31 Hinde Road, Bognor Regis, PO22 7QJ

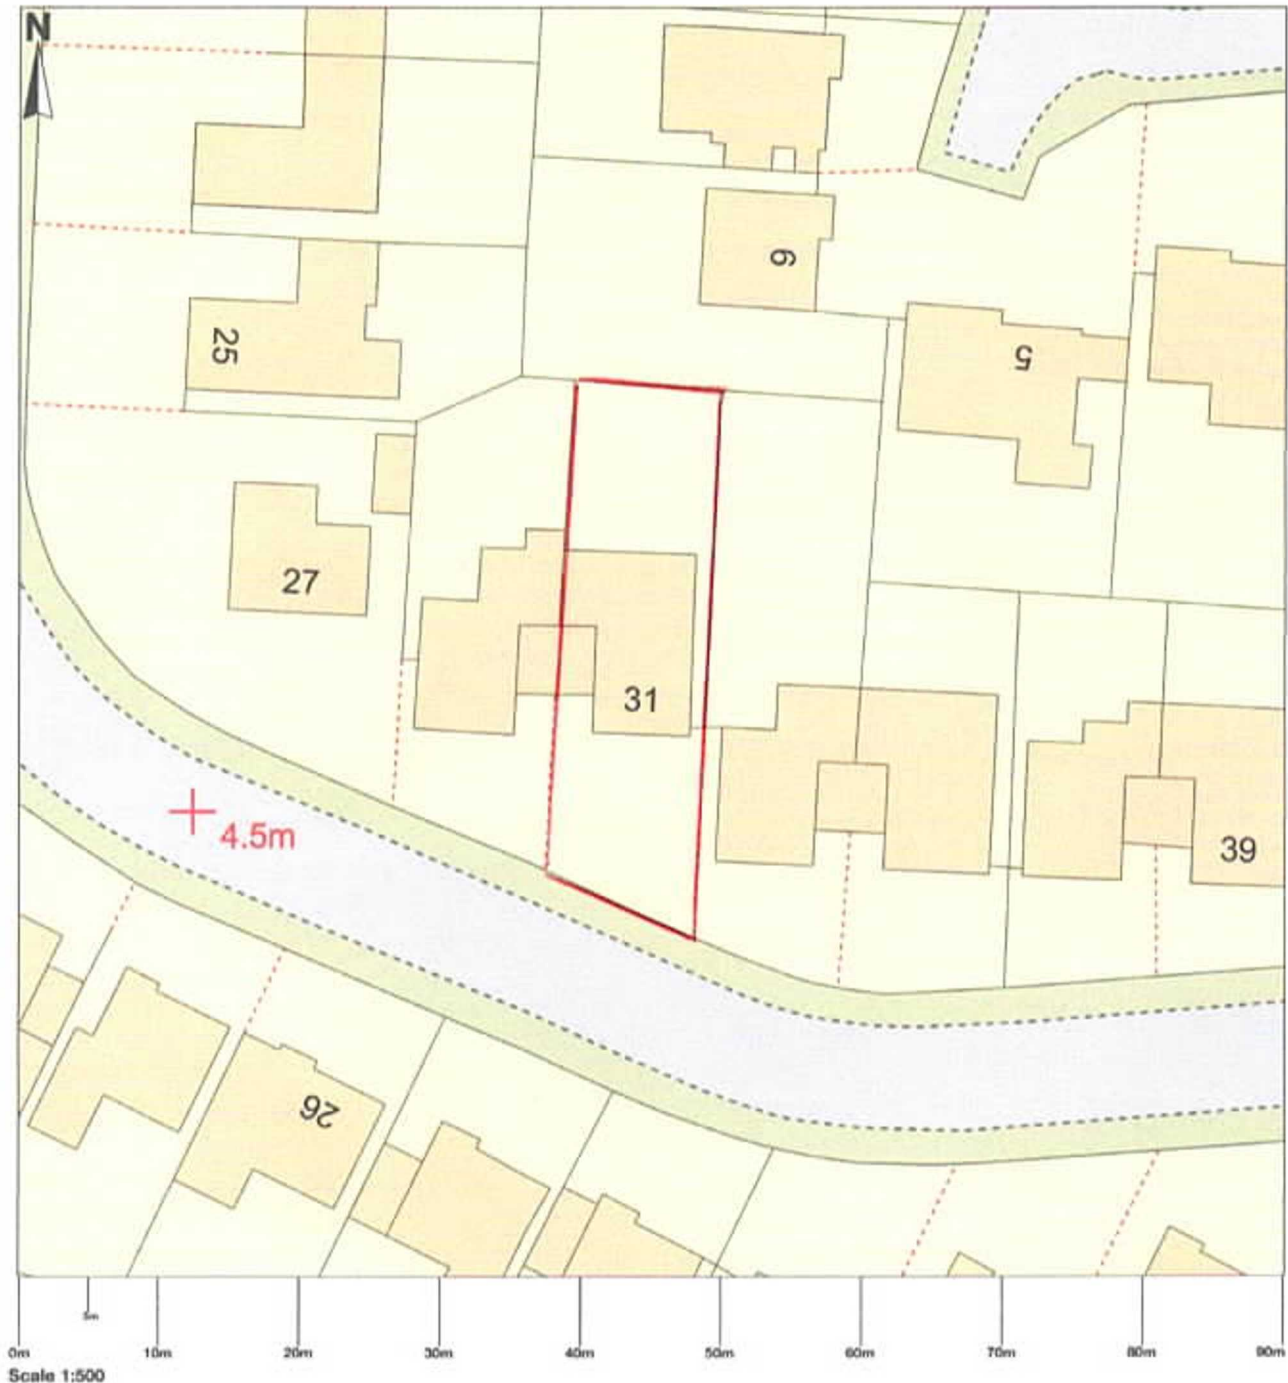
Block Plan: The scale bar on the site plan (1:500) does not measure to scale. Please amend.

EAST SIDE

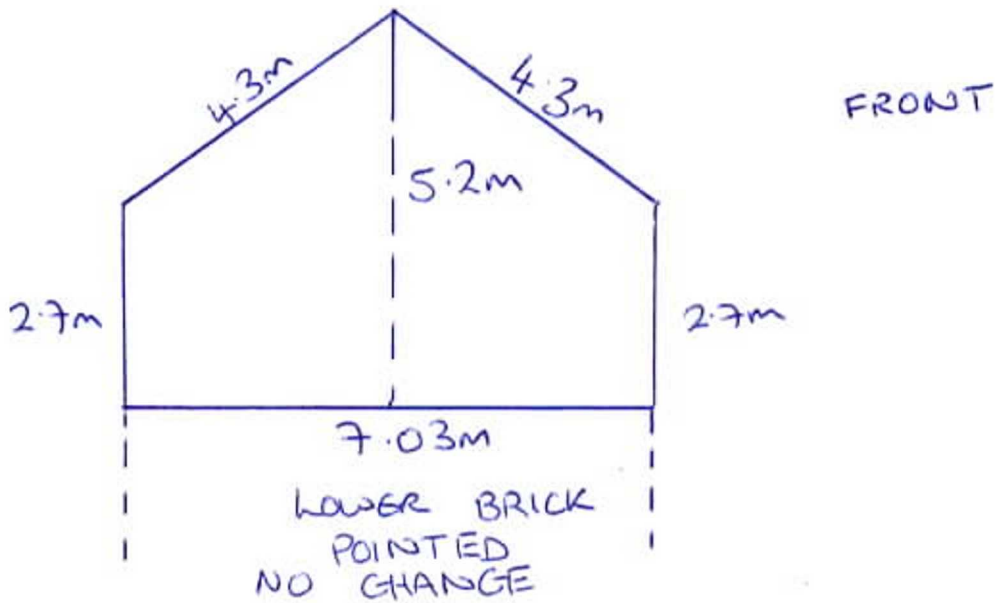
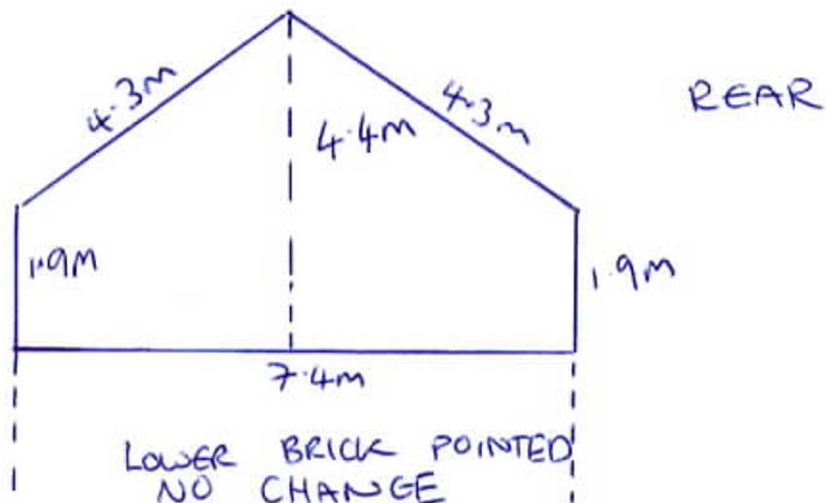
Elevations: These must be to scale. Please amend and display a scale so we are able to measure these.
